Scoping Opinion - Gortyrähilly Wind Farm, Ballingear, Co. Cork

Ecology Office Advices - Pre-Planning / General Scoping

PPW: 6225 Gortyrhilly Wind Farm, Co. Cork and PPW: 6226 Inchamore Wind Farm, Co. Cork

From: James Dwyer <James.Dwyer@CorkCoCo.ie>
Sent: Monday 4 July 2022 13:13
To: Sean Molloy <smolloy@jodireland.com>
Subject: RE: 6225 Gortyrahilly Wind Farm Ballyvourney Co. Cork - Grid Connection & Turbine Delivery Route Drawings

Legend

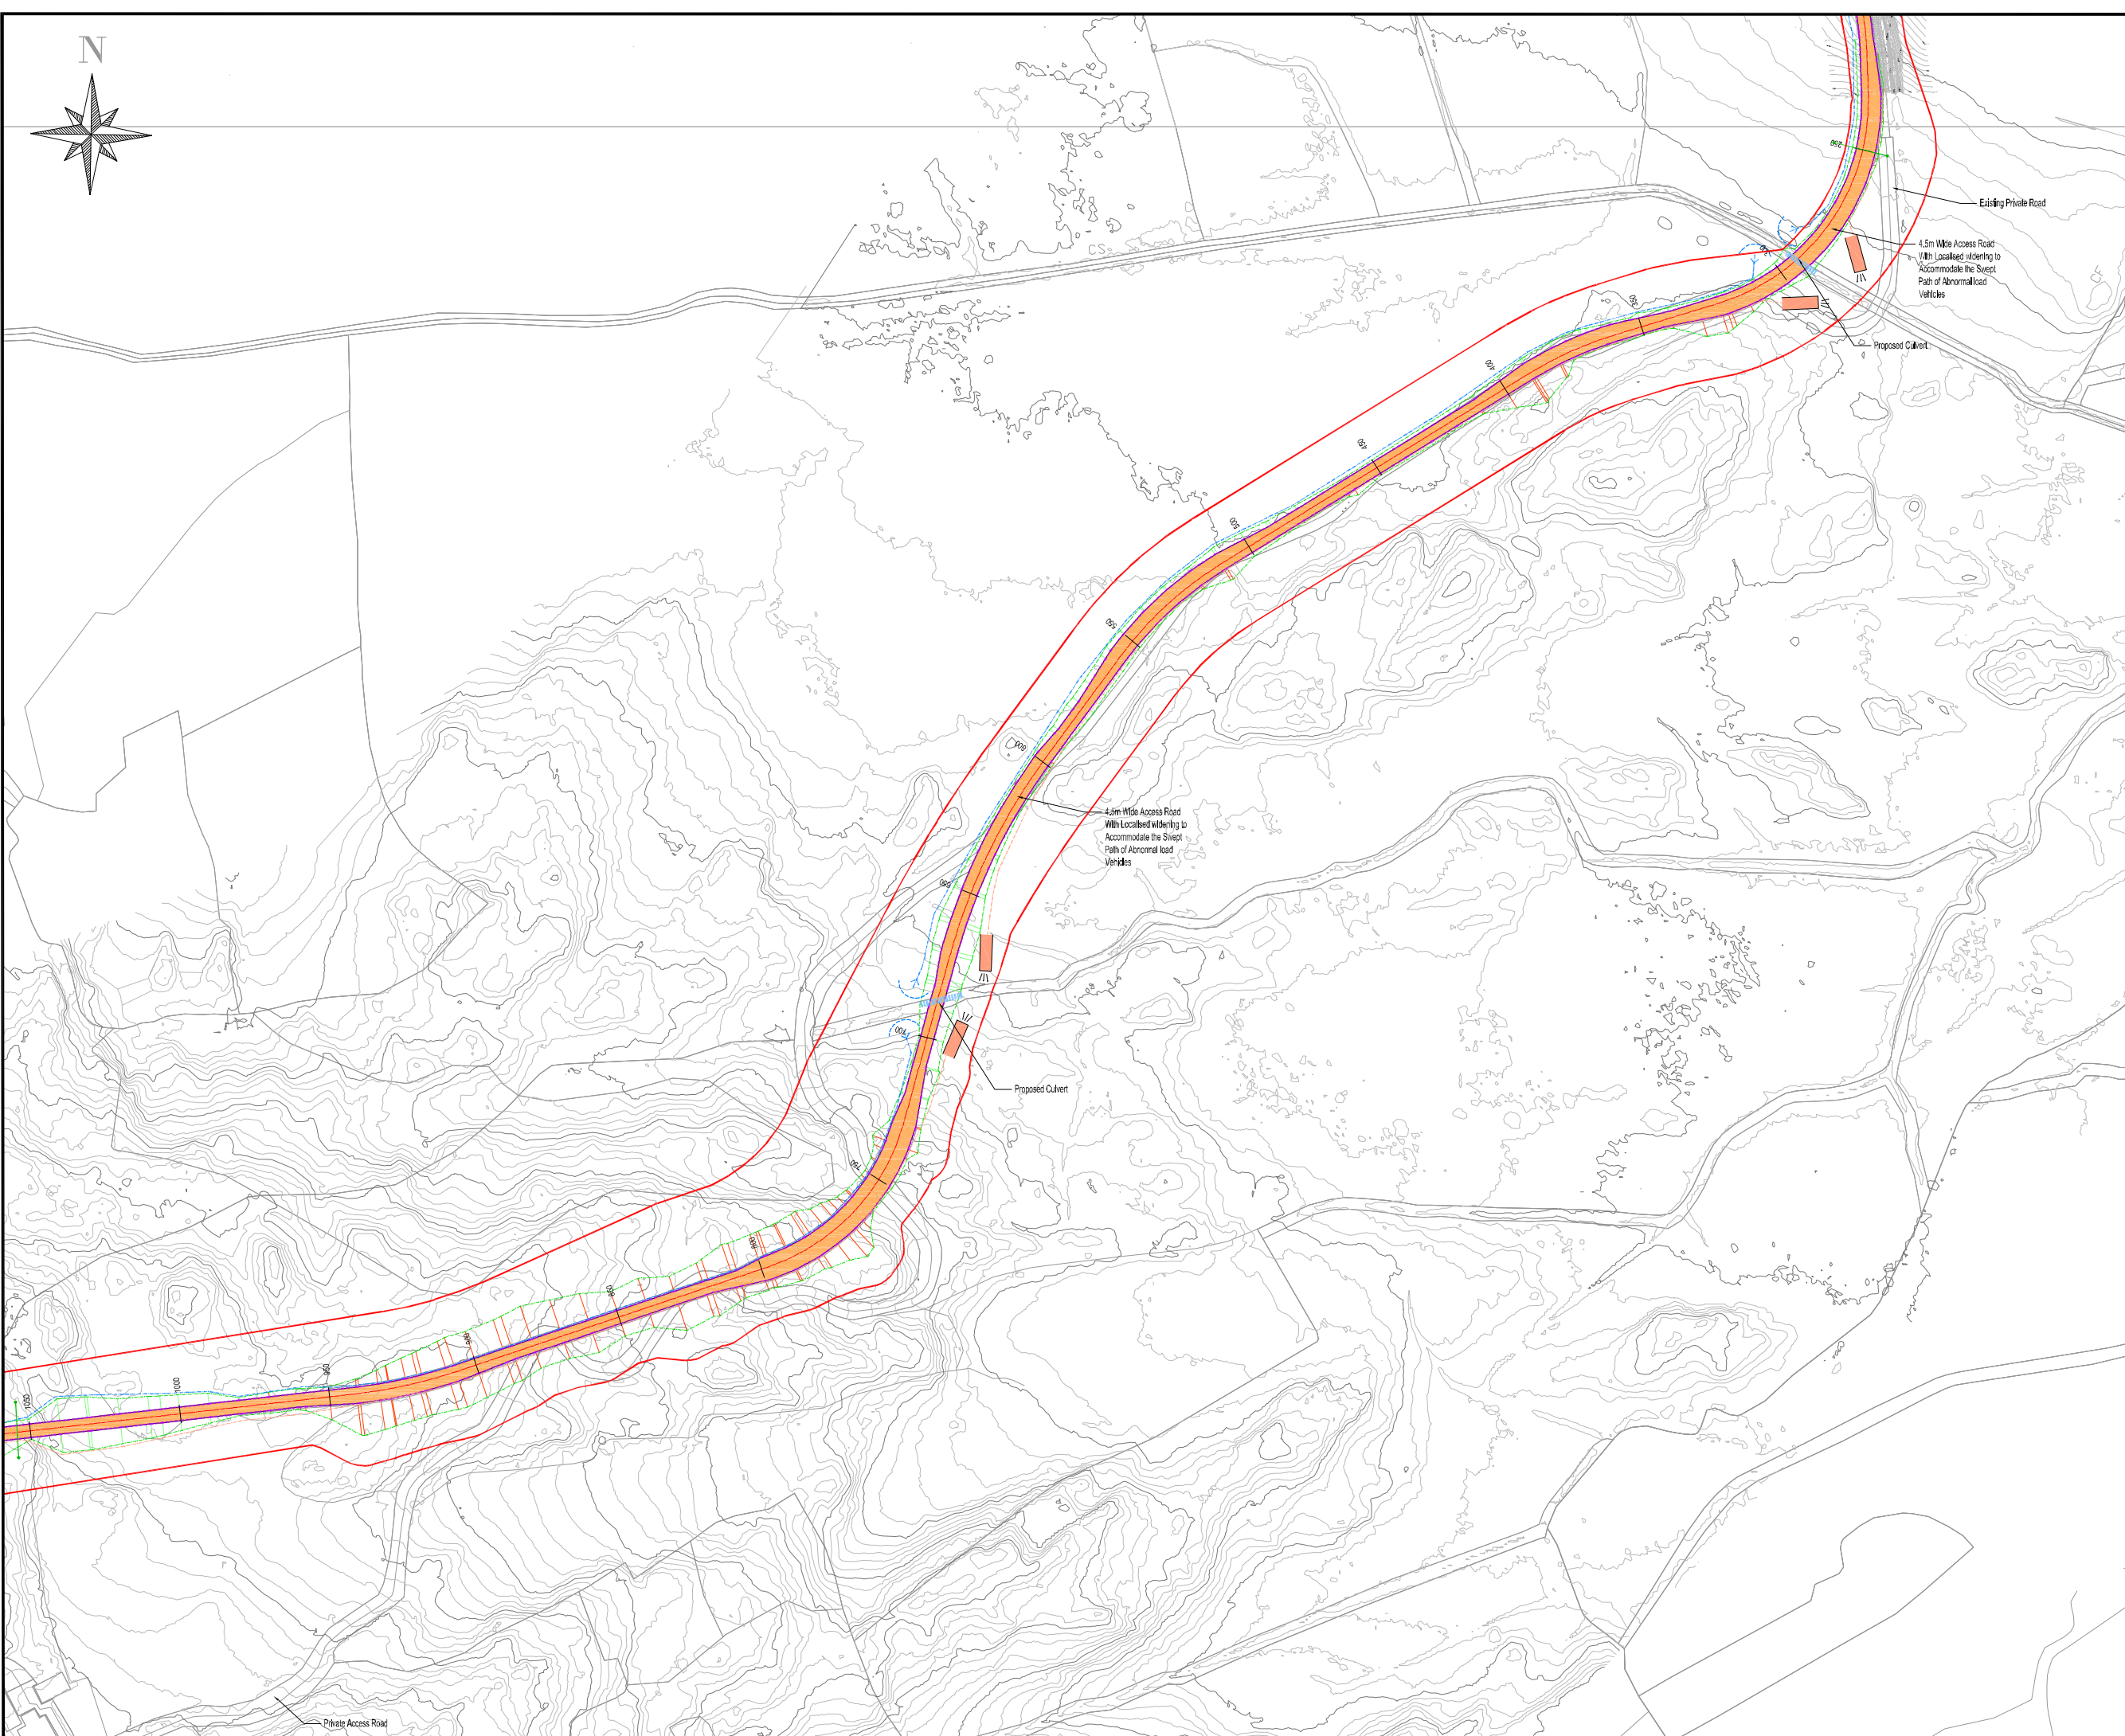
My comments on the delivery route are as follows:

- My previous comment re the junction off the N22.
- The consents for the re-installation of the temporary bridge could be difficult.
- Widening and strengthening of the local road network from the main Coolea/Ballyvourney road south will be required.
